SECTION 73 OF THE TOWN AND COUNTRY PLANNING ACT 1990 (AS AMENDED)
 PERMISSION TO VARY PLANNING CONDITION 1 ASSOCIATED WITH PLANNING CONSENT 22/00208/FP
 MONKSWOOD RETAIL PARK, ELDER WAY, STEVENAGE, SG1 1TL

On behalf of the applicant (GRIDSERVE Sustainable Energy Ltd), I hereby enclose various accompanying details in regard to the variation of condition relating to the electric vehicle charging hub and associated works at the Monkswood Retail Park, Elder Way, Stevenage, SG1 1TL

Sheet Name: Proposed Sectional Elevations

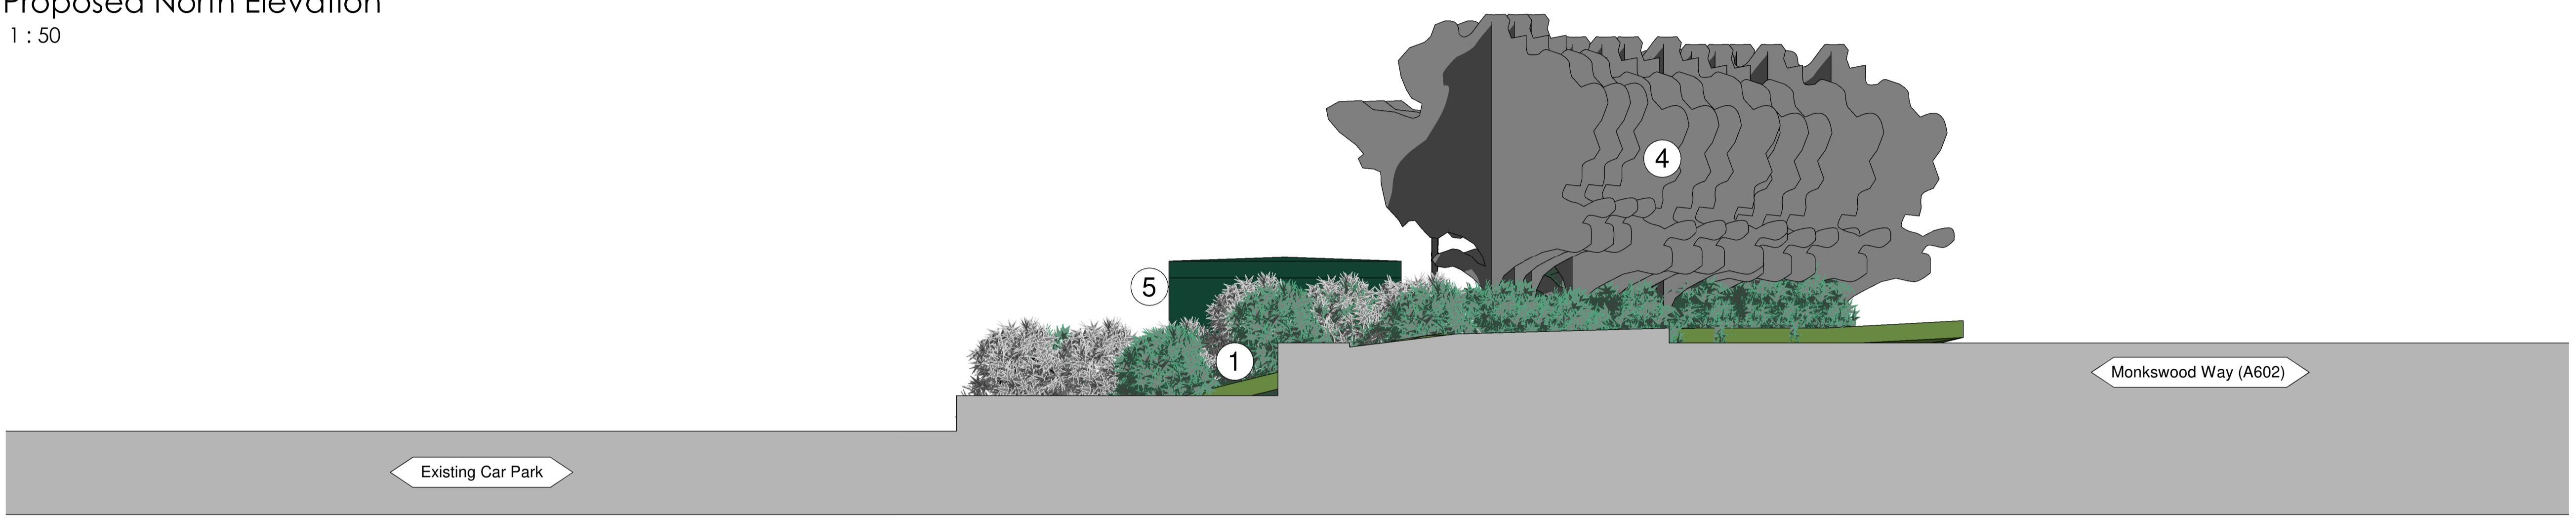
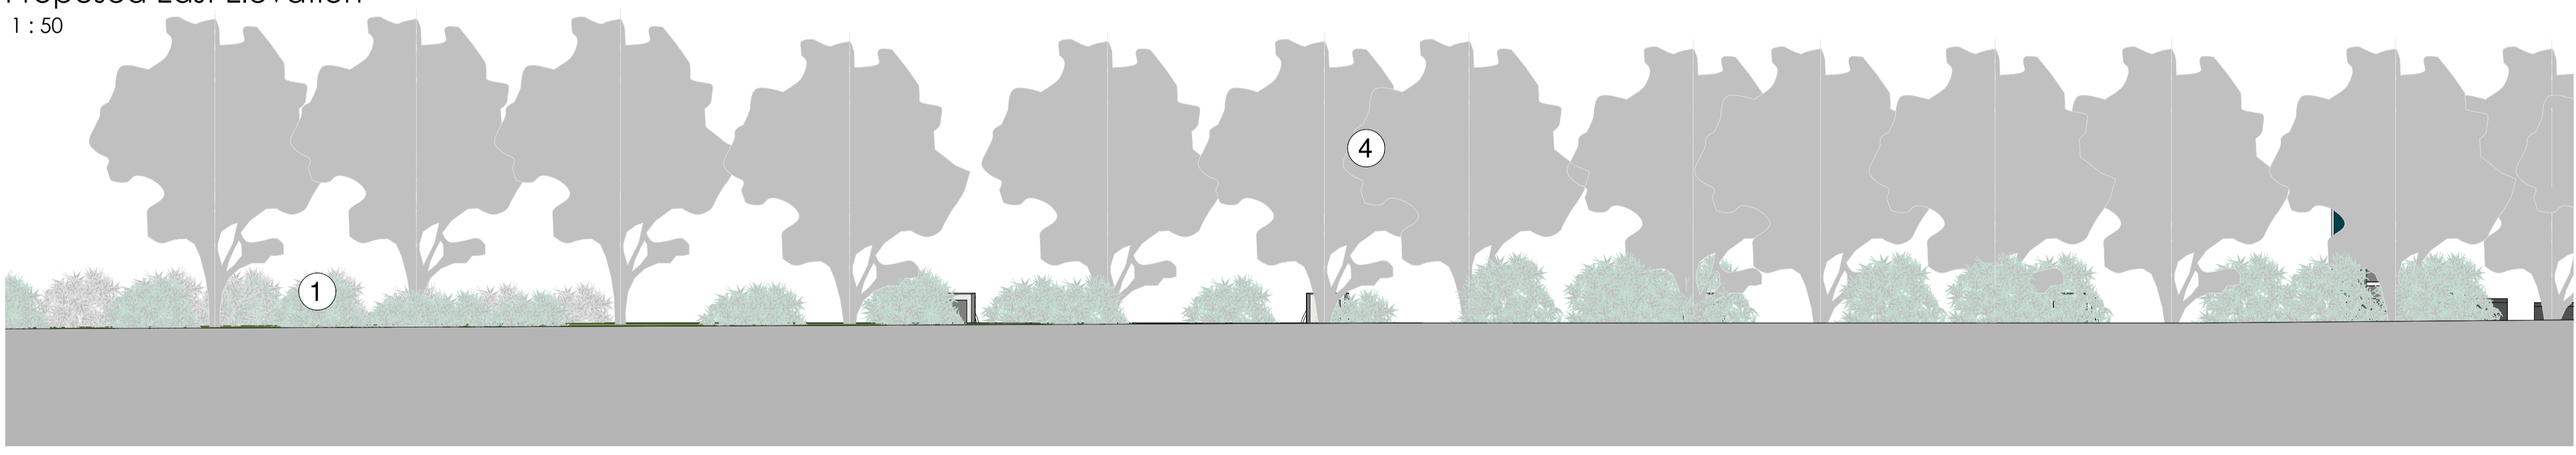
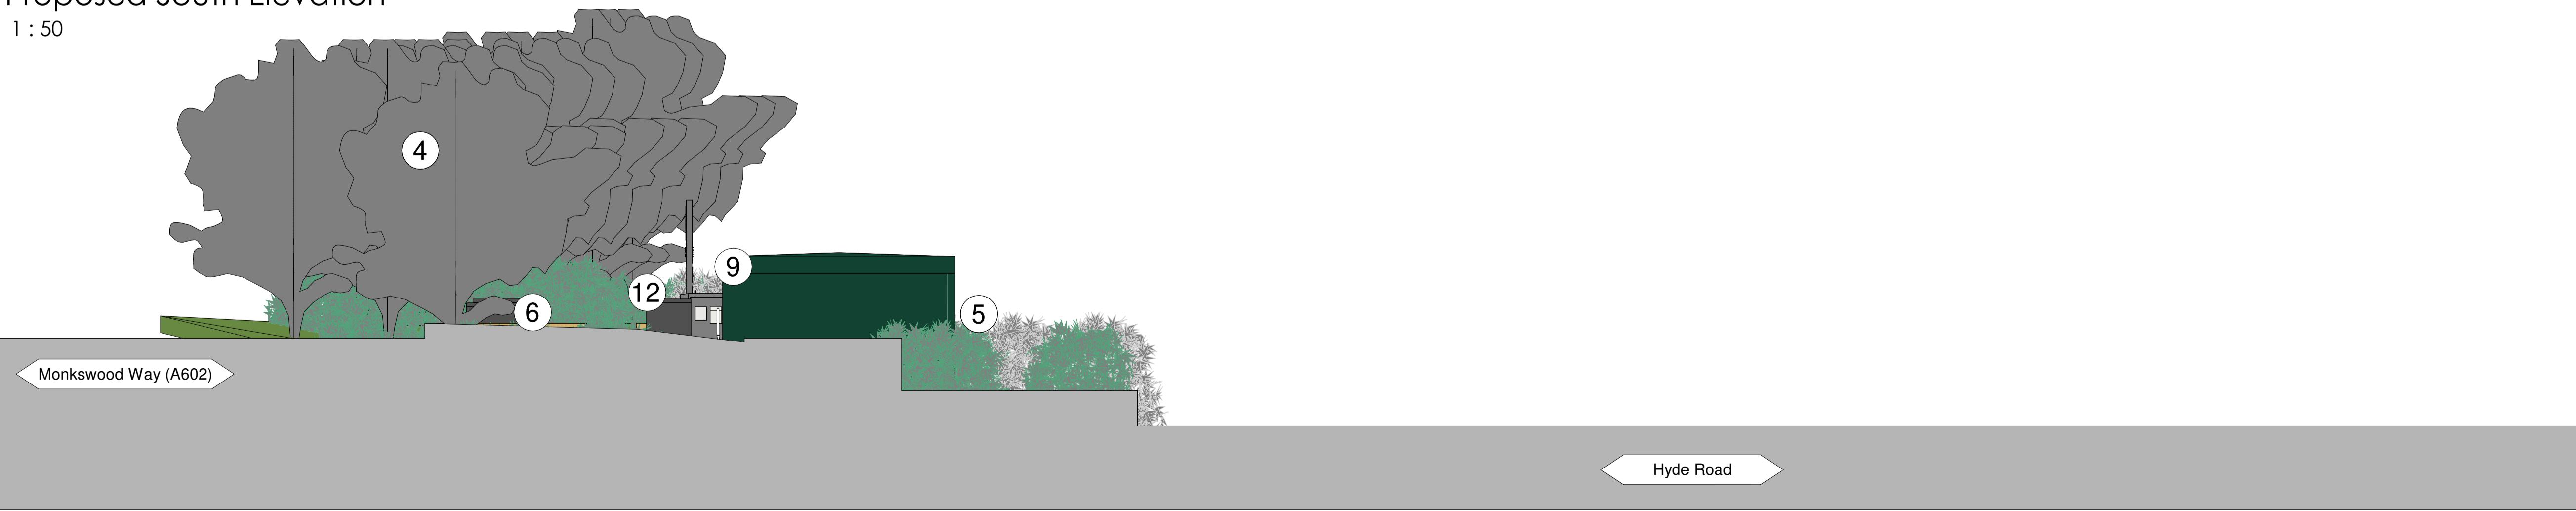
B. The replacement of the retaining wall. The technical review also identified that the retaining wall would need to be replaced. This is to ensure that there is sufficient space for the chargers. The replacement retaining wall will be a timber clad kingpost wall which will vary in height between 1.5m and 1m. The appearance of the wall will not be significantly different to the existing wall which would have needed replacement in the next few years. Although a replacement wall is proposed, it will be appropriate in scale and will not significantly alter the character and

<p>appearance of the area. It is not considered that the amendment will result in any additional impacts to those previously consented and the amendments remain within the developable area for the site.</p> <p>On the basis of the above it is proposed that the approved plan condition is updated as follows:</p> <p>Proposed Layout</p>  <p>New Condition Wording</p> <p>The development hereby approved shall be implemented in accordance with the following drawing number(s):</p> <p>The development hereby permitted shall be carried out in accordance with the following approved plans: 8650.15-BOW-A0-ZZ-DR-A-0102Rev P6; EV00598-E-GA-01 GRIDEVHUB-GA 8650.15-BOW-A0-ZZ-DR-A-0104Rev P6; REASON:- For the avoidance of doubt and in the interests of proper planning</p>
<p>2. The development hereby permitted shall be begun before the expiration of three years from the date of this permission. REASON:- To comply with the requirements of Section 91 of the Town and Country Planning Act 1990 (as amended by Section 51 of the Planning and Compulsory Purchase Act 2004).</p>	<p>There is no amendment to the time limit requested. It is expected that the EV Hub will be delivered in the next few months.</p>

Sheet Name: Proposed Site Plan
Purpose of issue: Planning Status:
Date: 05/04/22 Checked by: CR
Drawn by: LS Scale @ A1: 1 : 100
Project No: 8650.15 Revision: P6
Drawing No 8650.15-BOW-A0-ZZ-DR-A-0102

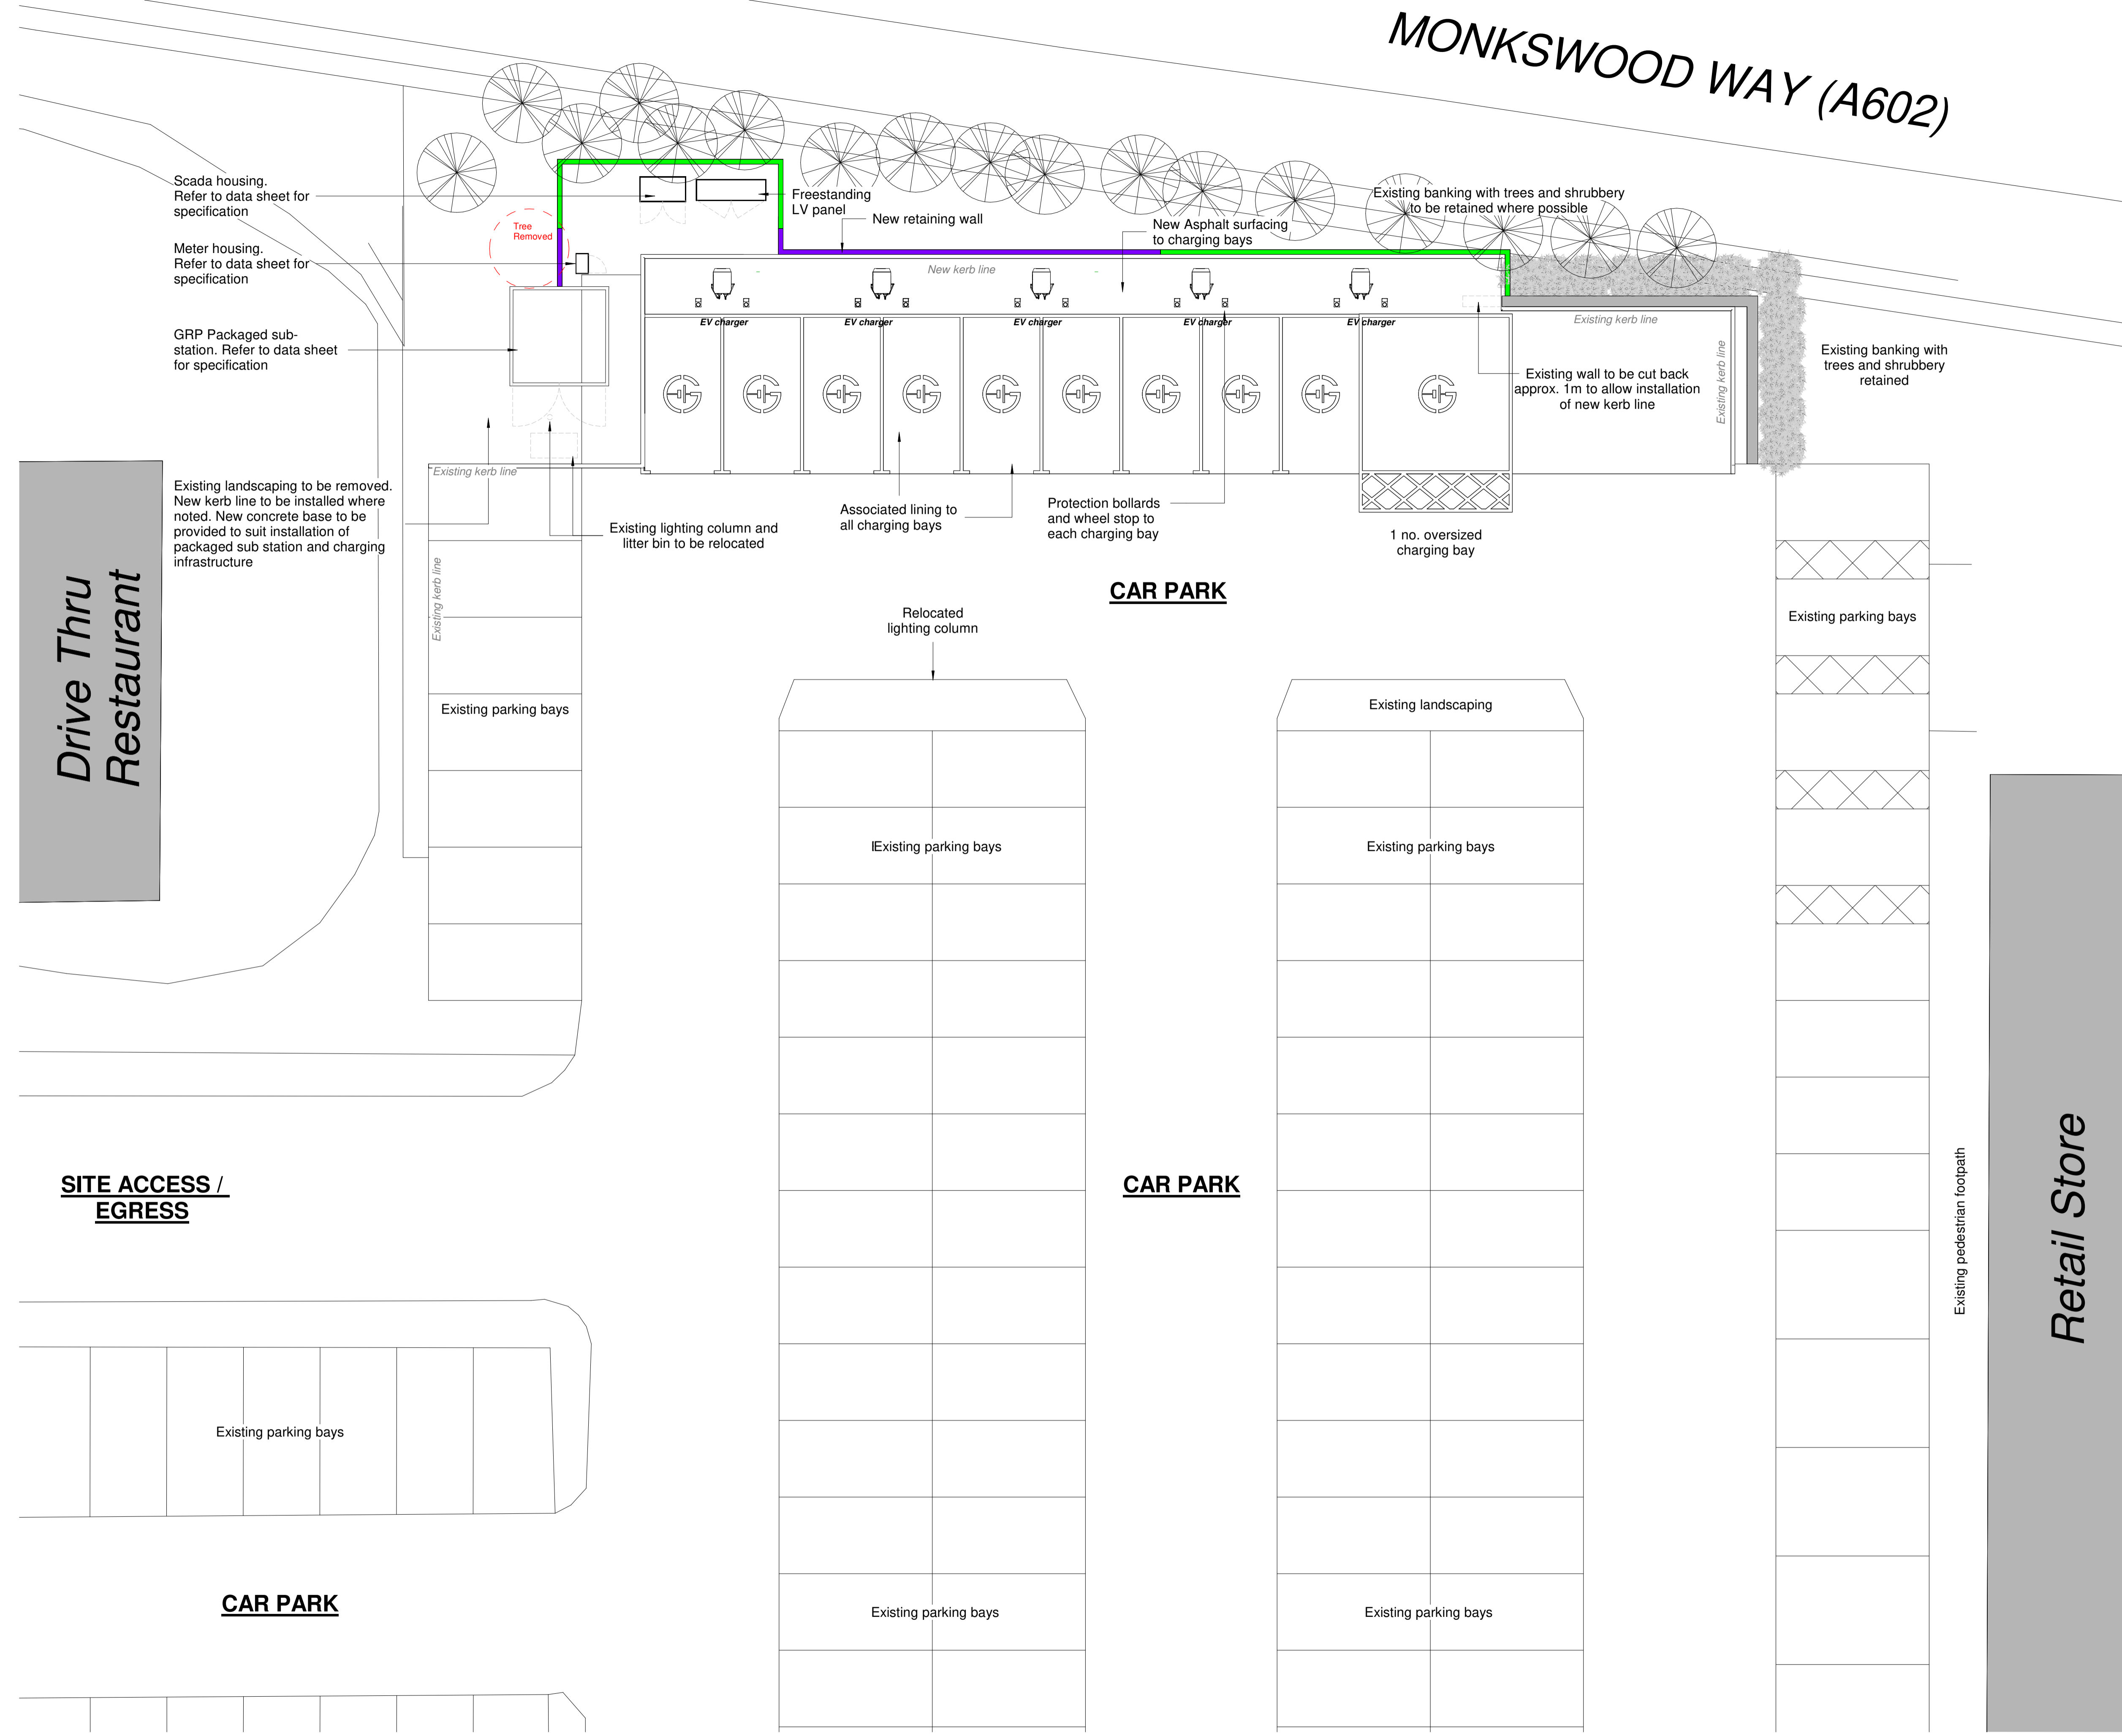
Planning Condition to vary (summary from Decision Notice)	Supporting Text and other Documentation
<p>1 - Approved plans; updated to reflect the revisions to the EV Hub layout</p> <p>A. Previous Approved drawing approved as part of the NMA.</p> 	<p>Following a technical review of the proposals the scheme has been amended. The following design amendments have been incorporated.</p> <p>A. The minor re-siting of the ancillary kit. Further investigation post consent has confirmed the presence of an easement for a gas main that was not previously identified on the initial utilities survey. The kit affected includes the substation, meter cabinet, feeder pillar and communications cabinet (SCADA). The re-siting has also necessitated the removal of the circulation areas between the bays and the regrading of the bank and the removal of some of the shrubbery and a tree. As such the revision to the layout will reduce the visual impact of the ancillary kit as the setting down</p>

of the kit through the regrading will mean that the kit's impact from the road will be significantly reduced. This regrading will also aid maintenance and remove a working at height safety issue that came to light post consent. The appearance of the kit will remain as previously consented. This will result in some minor loss of landscaping with the remainder being retained. The bay sizes will mirror standard car park bay sizes and will match the rest of the car park. It is not considered that the amendments will result in any significant impacts over and above those previously consented and they remain within the developable area for the site.

Proposed new layout
